From: Claire Rodway
Sent: 06 September 2010 08:59
To: Planning.Responses
Subject: FW: Planning Consultation

Outline application for redevelopment of site: Demolition of 2 bungalows, workshop, glasshouses and incidental development with erection of 91 dwellings with improved means of

Windroos Nursery, Worthing Road, Littlehampton. Ref: LU/229/10/

35. Indicative floor plan of the flats in the north east corner of the site

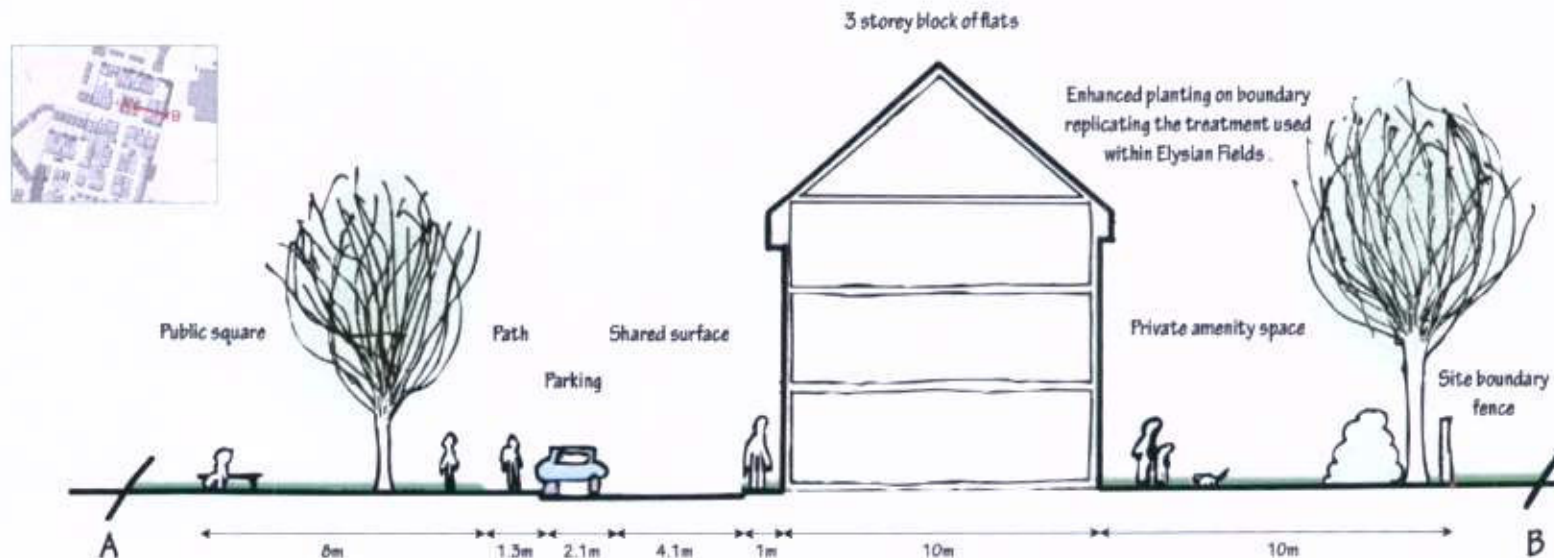
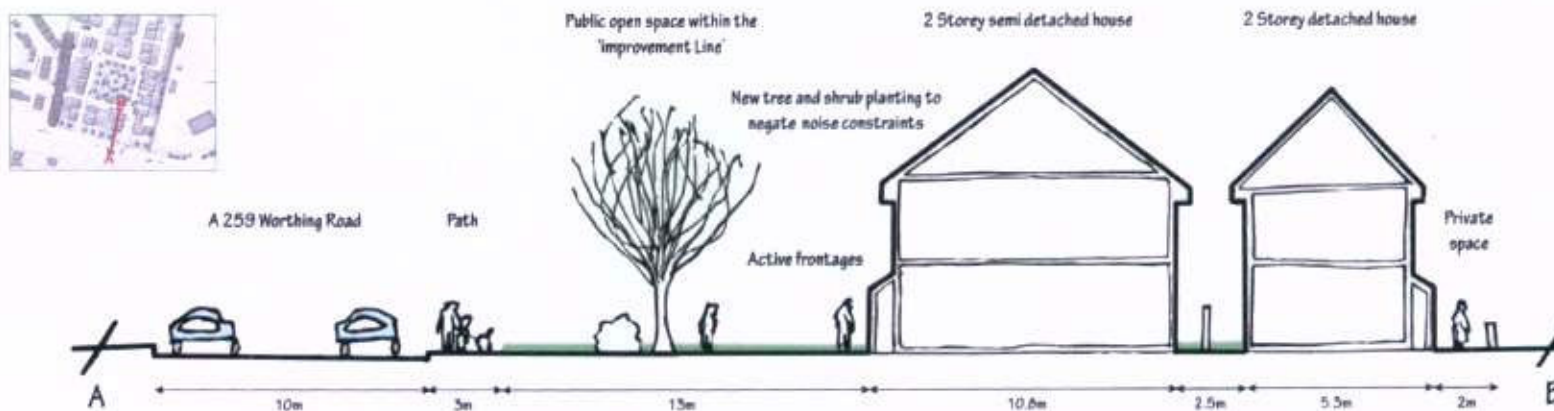
I did consider the impact of noise on the proposed development & concurred with the views contained within the chapter on Noise Attenuation contained in the Design & Access Statement. On reflection you may wish to consider requesting detail of facade attenuation measures proposed to habitable rooms fronting the A259 & the adjacent Watersmead Business Park (current plans do not indicate a boundary with the railway line) and specification of boundary attenuation measures indicated in the north-east corner of the site.
